**KIRKLEES METROPOLITAN COUNCIL  
INVESTMENT & REGENERATION SERVICE**

**DELEGATED DECISION TO DETERMINE PLANNING APPLICATIONS**

Reference No:	<b>2024/62/90692/W</b>
Site Address:	19, Spa Bottom, Fenay Bridge, Huddersfield, HD8 0BB
Description:	Erection of first floor rear extension with projecting balcony and front porch
Recommending Officer:	Laura Yeadon

**DECISION – CONDITIONAL FULL PERMISISON**

Proposed front/east facing elevation (1:100)

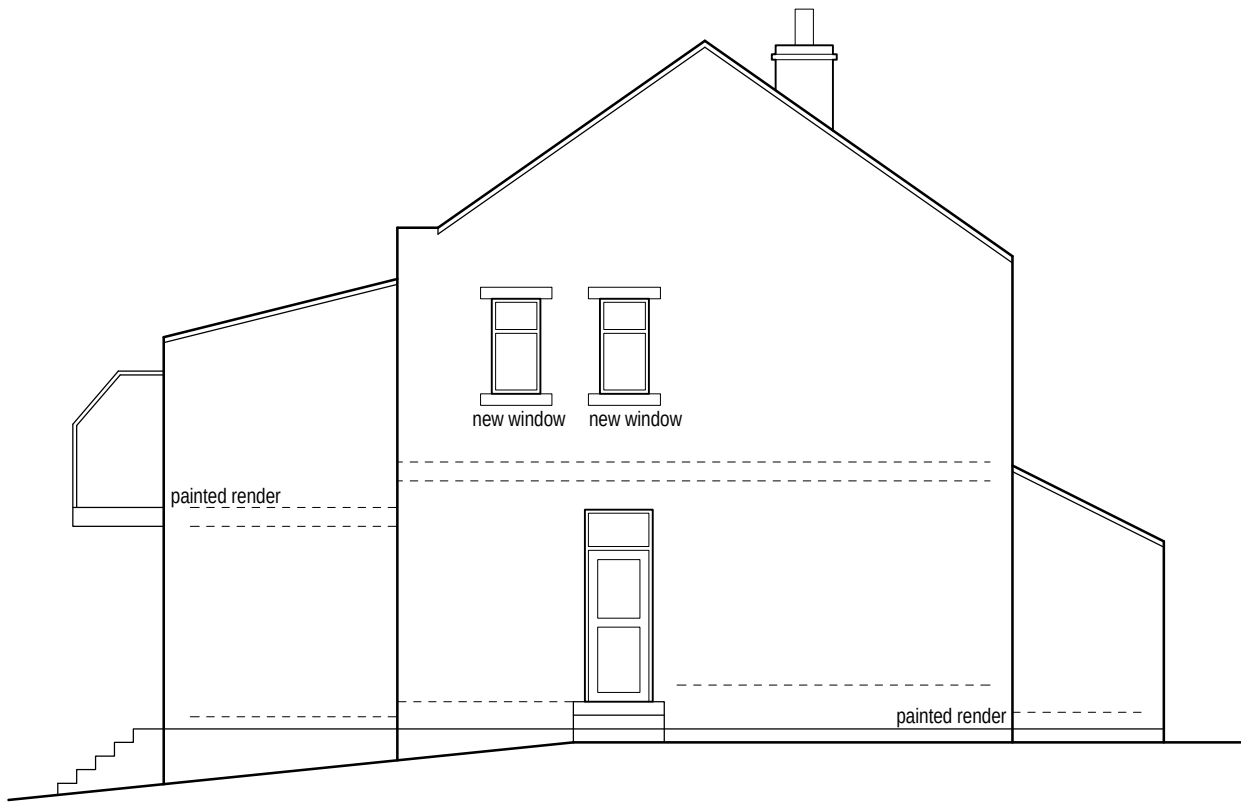
- High risk of serious harm/injury from exiting the property directly onto the road from proposed porch doorway into the path of moving vehicles – suggest that the porch is reduced in depth to prevent exiting directly onto the road/moving vehicles

- High risk of serious harm/injury from exiting the property directly onto the road from proposed porch doorway into the path of moving vehicles – suggest that the porch is reduced in depth to prevent exiting directly onto the road/moving vehicles

Response: The porch would be located within the confines of the site boundary and the plans indicate that the doorway would be inward opening. This is considered to suitably mitigate the risk associated with this element of the proposal in relation to highway safety.

Proposed side/soth facing elevation (1:100)

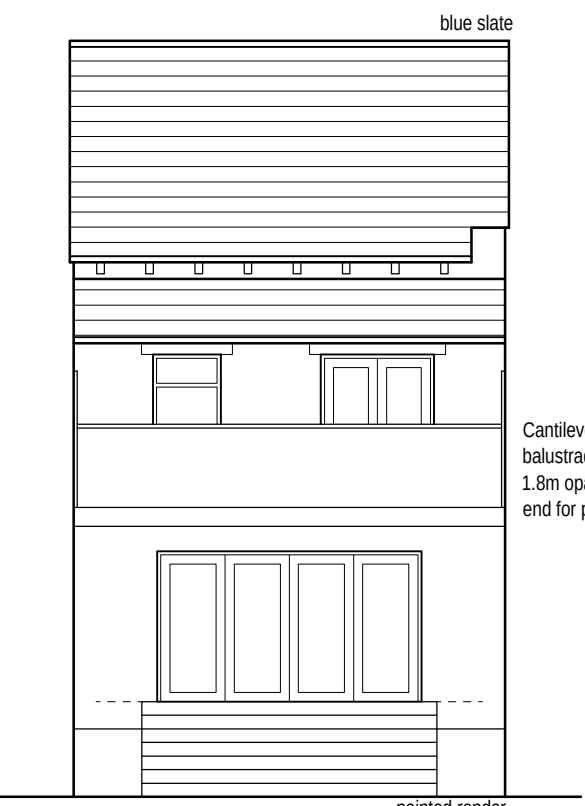
- Loss of privacy from additional proposed windows in south elevation overlooking habitable space in neighbouring property – suggested that the en-suite window is as small as possible and top opening only and with appropriate privacy glass

- Loss of privacy from additional proposed windows in south elevation overlooking habitable space in neighbouring property – suggested that the en-suite window is as small as possible and top opening only and with appropriate privacy glass

Response: This has been addressed above and a condition can be attached to ensure that the openings are obscurely glazed and top opening only

5. The first floor rear extension shall not be occupied until the first floor windows inserted within the north and south elevations of the building have been obscure glazed to a minimum Grade 4 and shall be top-opening only. Notwithstanding the provisions of the Town and Country Planning (General Permitted Development) Order 2015 as amended (or any Order revoking or re-enacting that Order) the obscure glazing shall thereafter be retained.

Proposed rear/west facing elevation (1:100)

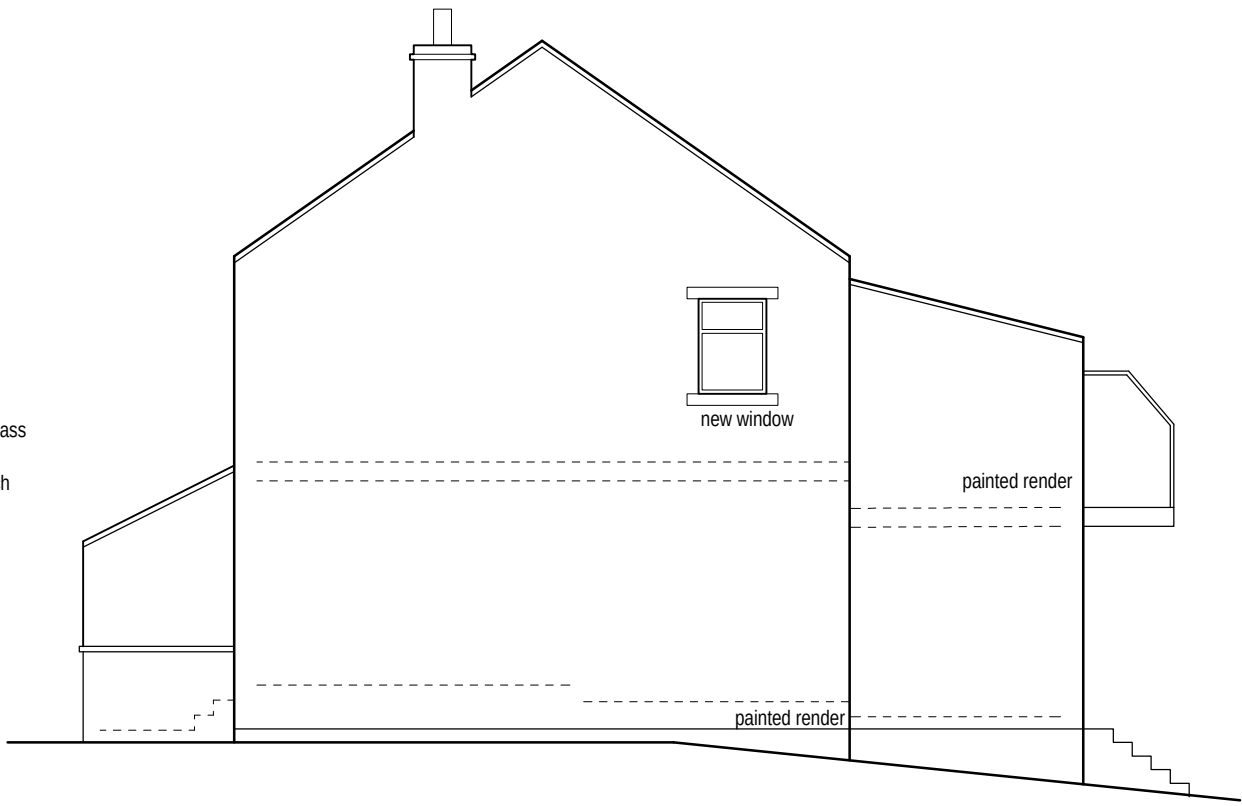
The proposed balcony would be in a cantilever style and would project off the rear elevation by 1.2 metres at first floor level. It is proposed that 1m high balustrade would be installed on the rear elevation of the balcony with 1.8m high opaque glass screening to each side of the balcony.

With regard to the proposed balcony, this would be located on the rear elevation of the extension of the property and would have a limited projection of 1.2 metres. The balcony would be cantilever in its design with opaque glass to each side elevation giving a lightweight appearance. In terms of visual amenity, this is also considered to be acceptable.

There is a raised terraced area to the rear of No. 21 and due to the orientation, the rear elevation of the existing first floor of the host property is set back from the rear elevation of the neighbouring property. The presence of the first floor extension and balcony is likely to cause some level of overshadowing to the terraced area of No. 21 however this is mitigated as far as practicable by virtue of the roof line and eaves height being set down from the existing, the projection being limited to 3.1 metres and the side of the balcony being glazed, albeit opaque. Whilst some level of harm would be created due to the presence of the structure, it is not considered to be so harmful that there would justify the refusal of permission in this case.

1.8 metre high opaque glass is proposed to the side elevations of the balcony, as demonstrated on plan, however this can be conditioned to ensure that privacy levels are met. It is also proposed that windows would be created in the side elevations of the existing property. Due to the proximity of these openings to neighbouring dwellings, it is considered reasonable and necessary in this instance to condition that these are also obscurely glazed.

4. The balcony shall not be brought into use until the side elevations have been installed with 1.8m high obscure glazing to a minimum Grade 4. Notwithstanding the provisions of section 55(2) (a) (ii) of the Town and Country Planning Act 1990 and the Town and Country Planning (General Permitted Development) Order 2015 (or any order revoking or re-enacting that Act or Order with or without modification) this balcony shall thereafter be retained the 1.8m high obscure glazing.
